RE: Campbelltown Hospital Redevelopment Stage 2 (SSD 9241)

Thank you for your letter dated 27 August 2018 requesting Transport for NSW (TfNSW) provide comment on the above State Significant Development (SSD 9241).

The proposed Stage 2 of the redevelopment includes the: demolition of existing structures; construction of a new 13 storey Clinical Services Building; construction of augmented and new internal Hospital access roads and links, including a connection to Appin Road and Therry Road; and construction of an at-grade car park.

1 PLAN - PROPOSED ROADWORK - MAIN ENTRY
1 : 1000

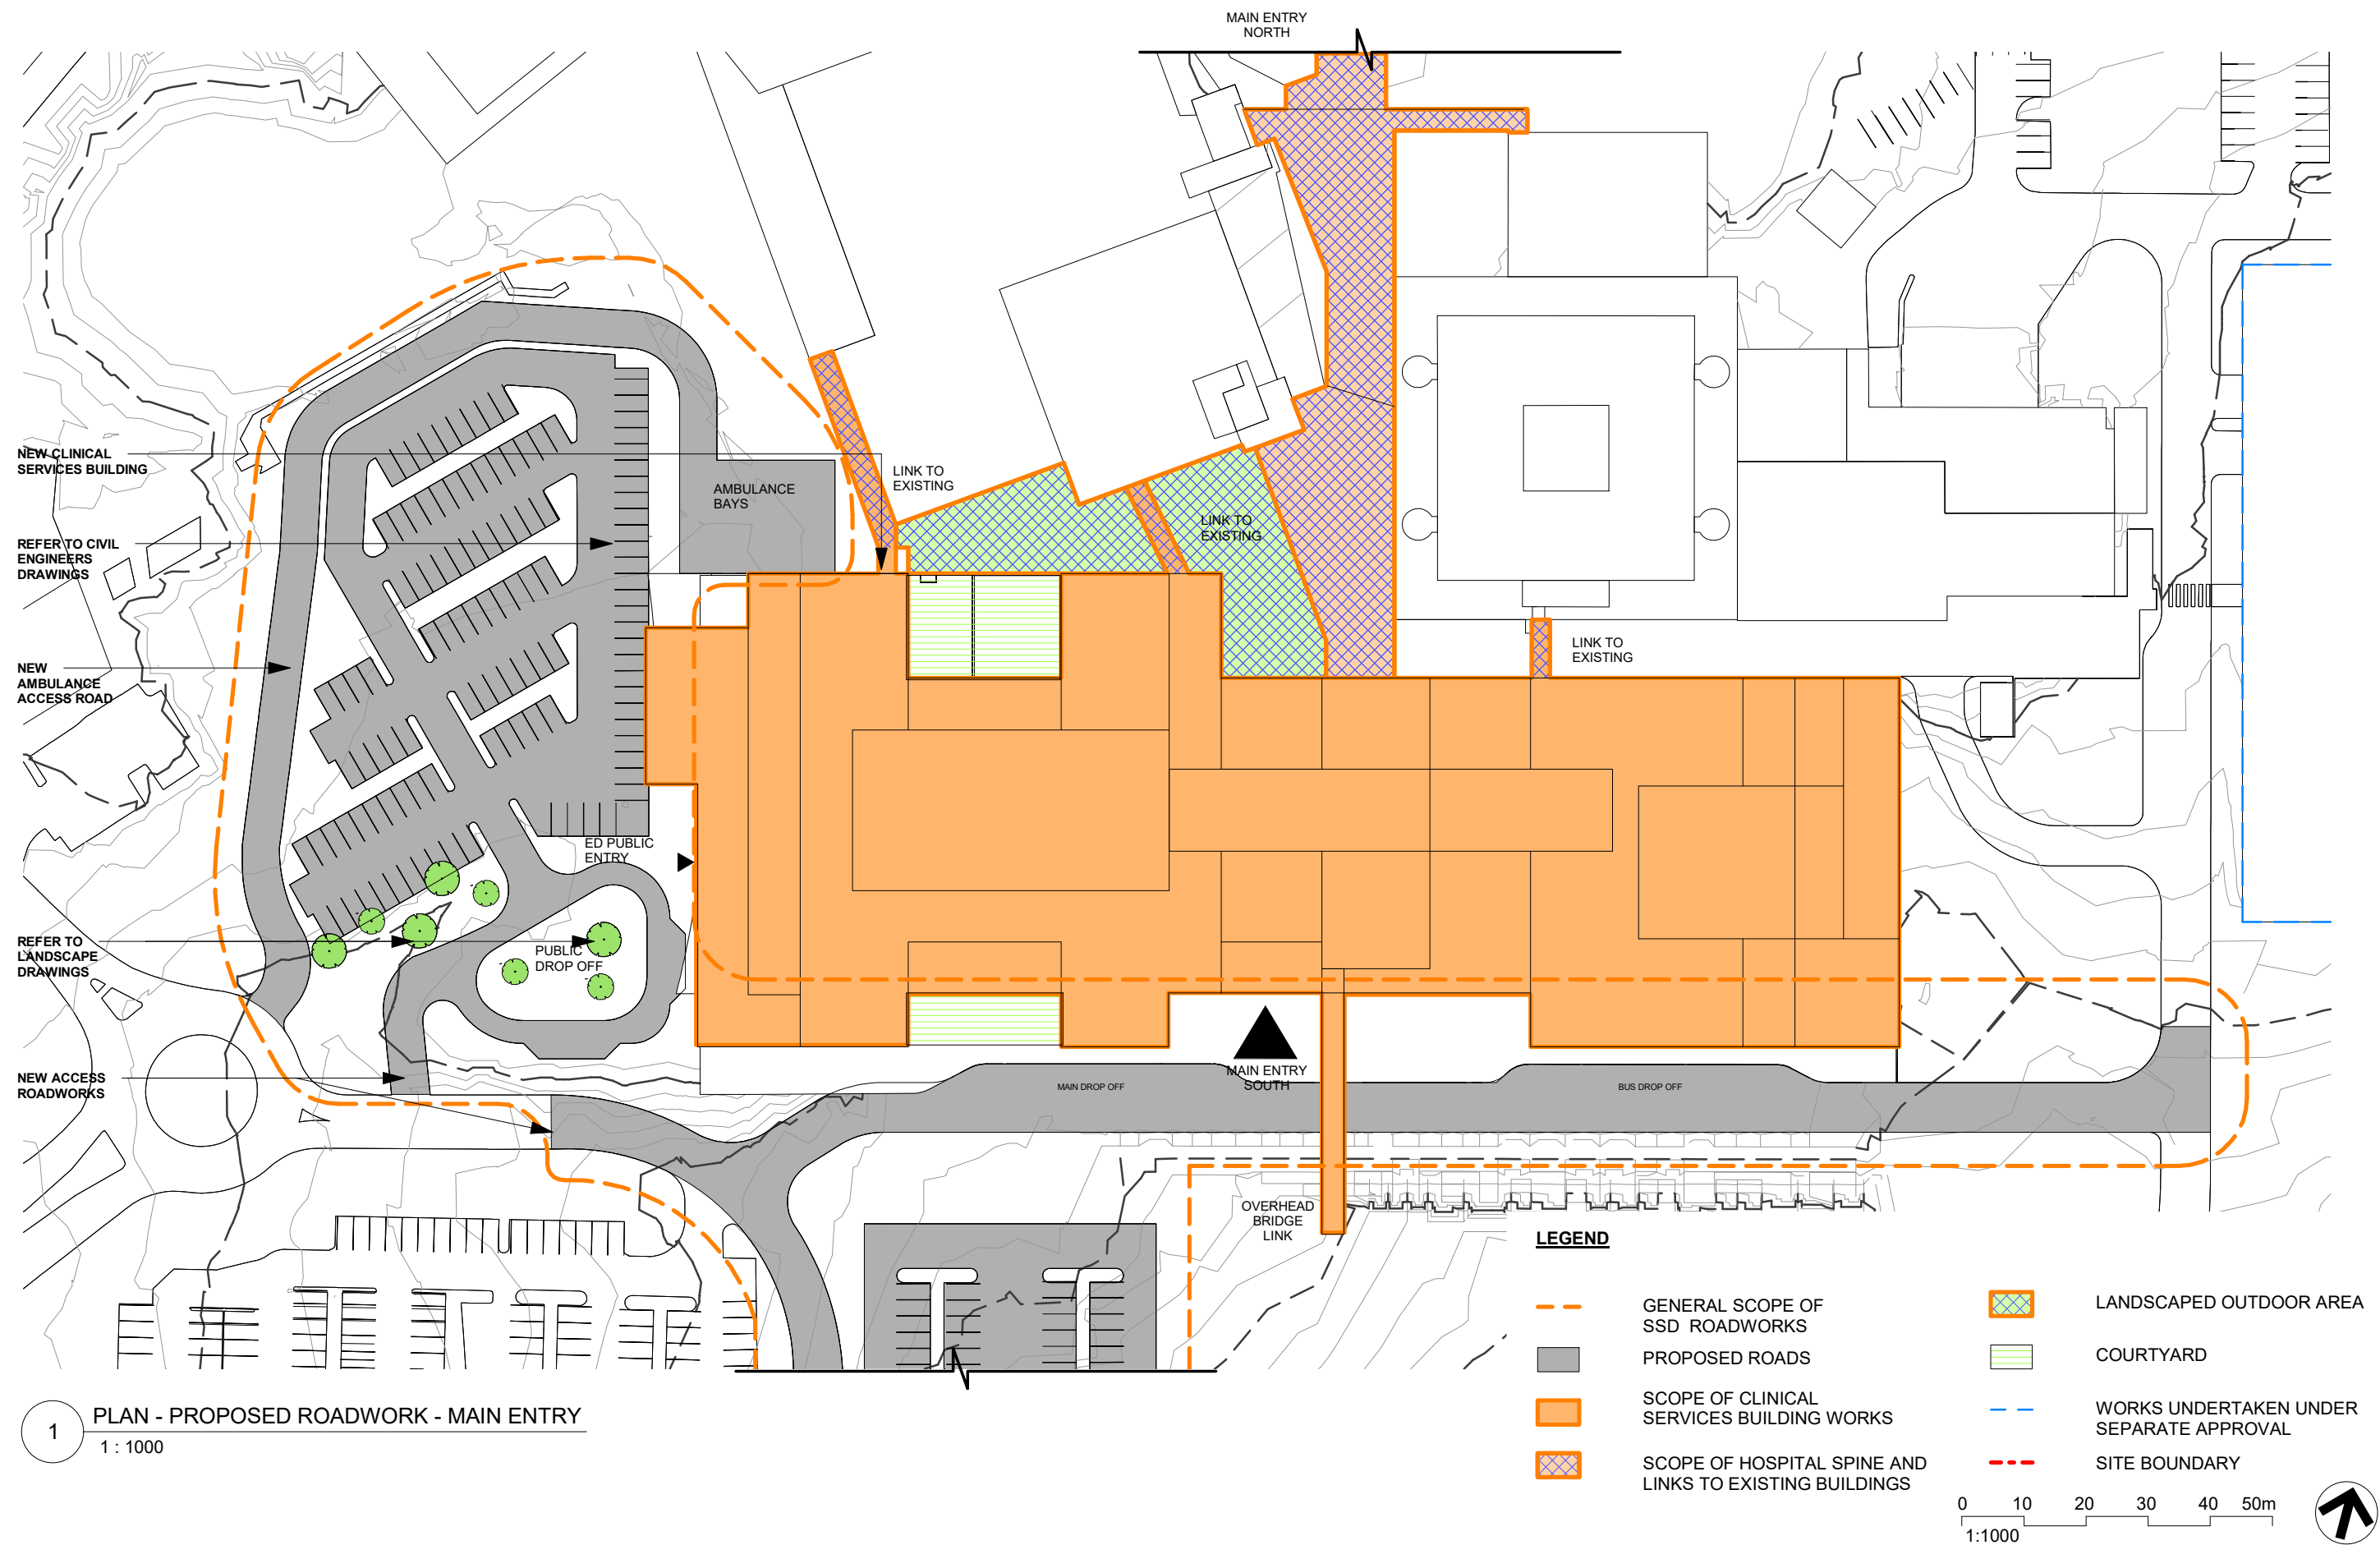
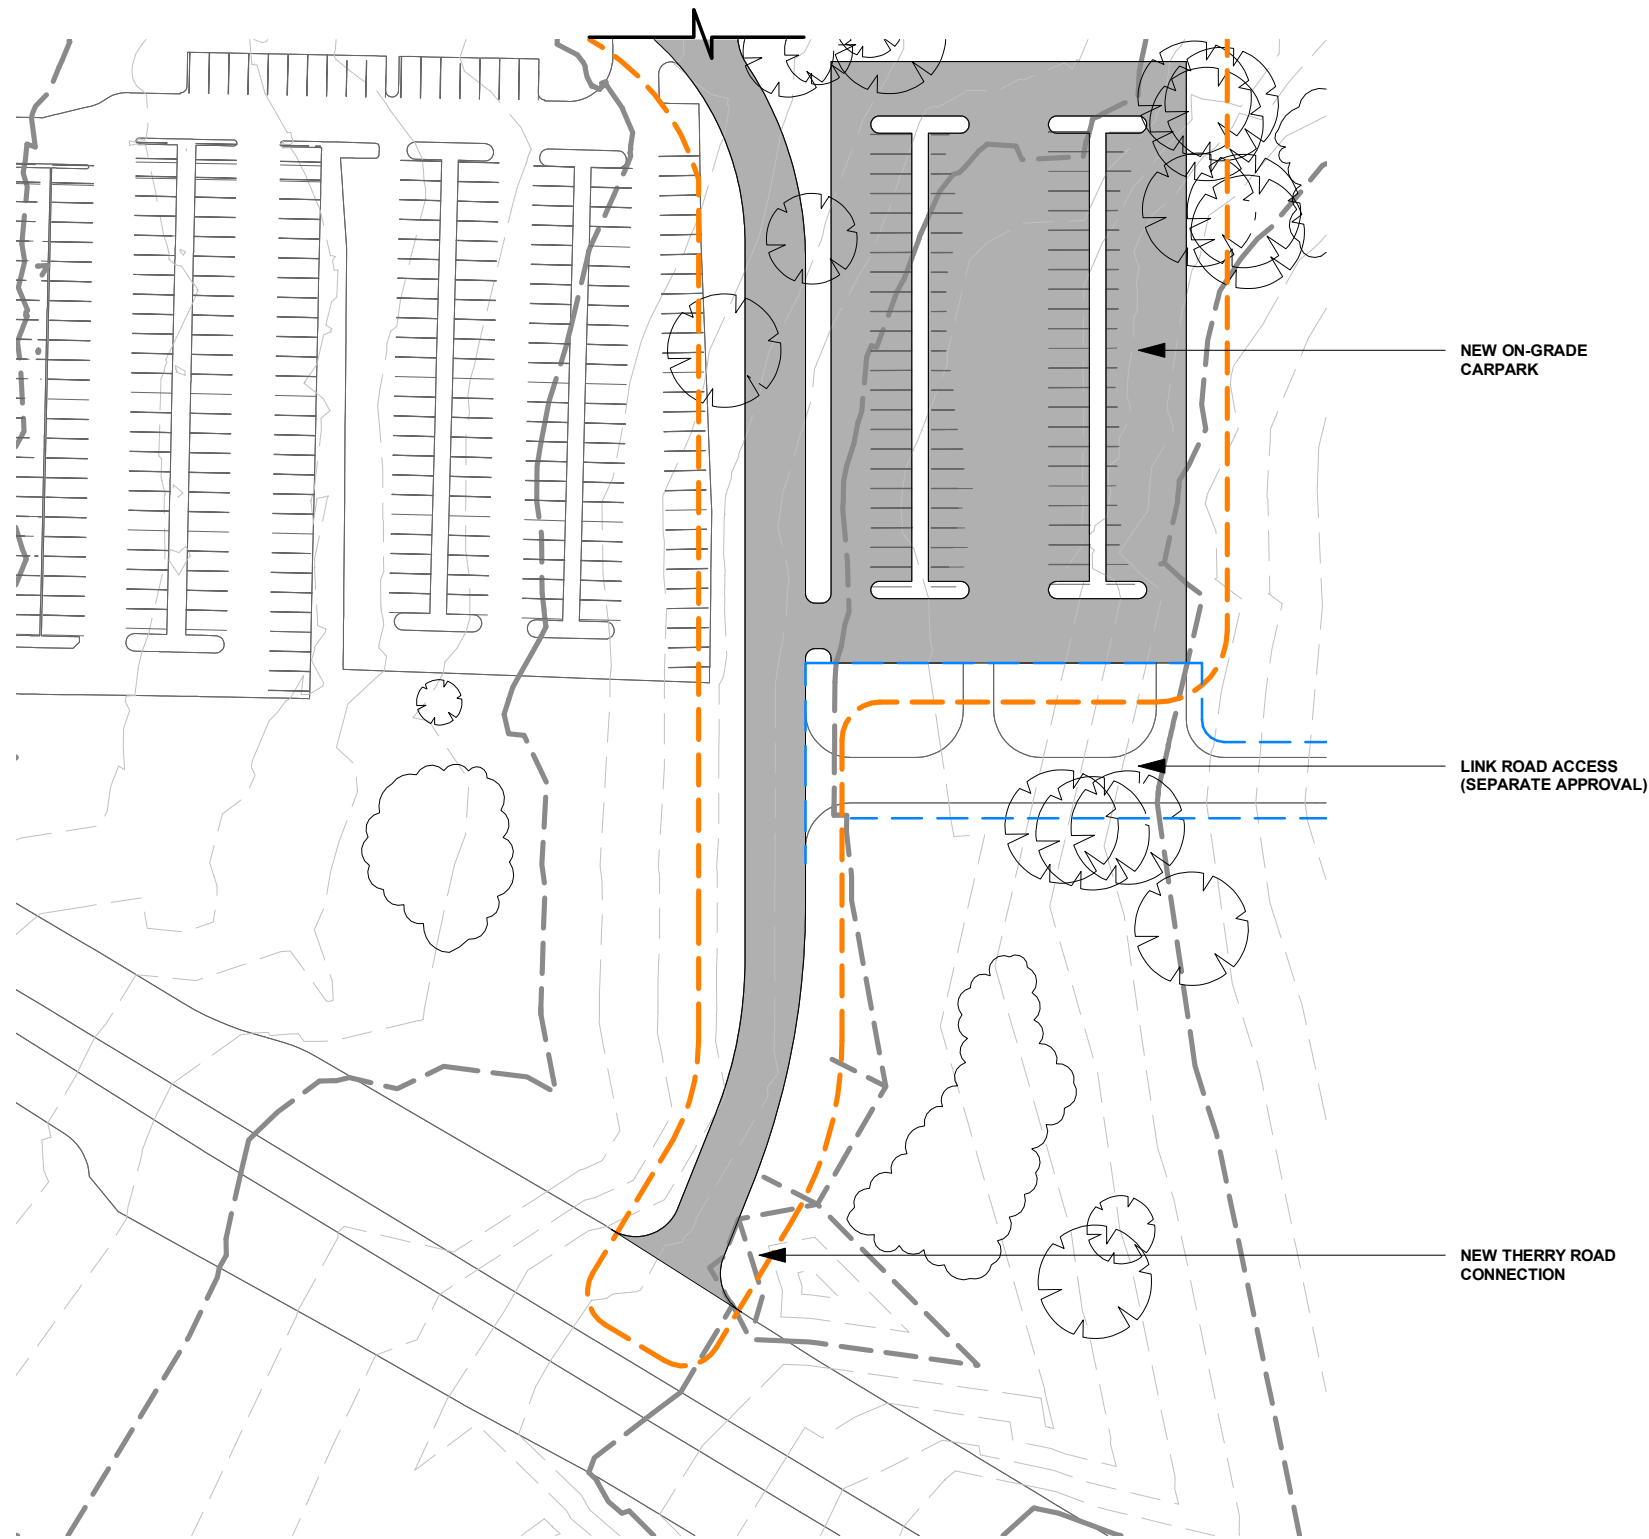
The following comments are provided for consideration to ensure the internal Hospital road network is bus capable:

- All access roads need to be 3.5m in width.
- Medians should not be included on roads that may be used by buses.
- A reservation of 30m set down space, 30m for pick-up space and approximately 50m lay-up space is required for buses accessing the Hospital site.
- A minimum 14.5m bus template turning at 5 – 15km/h is to be used.
- A turning diameter of 30m to be used when designing public transport infrastructure.
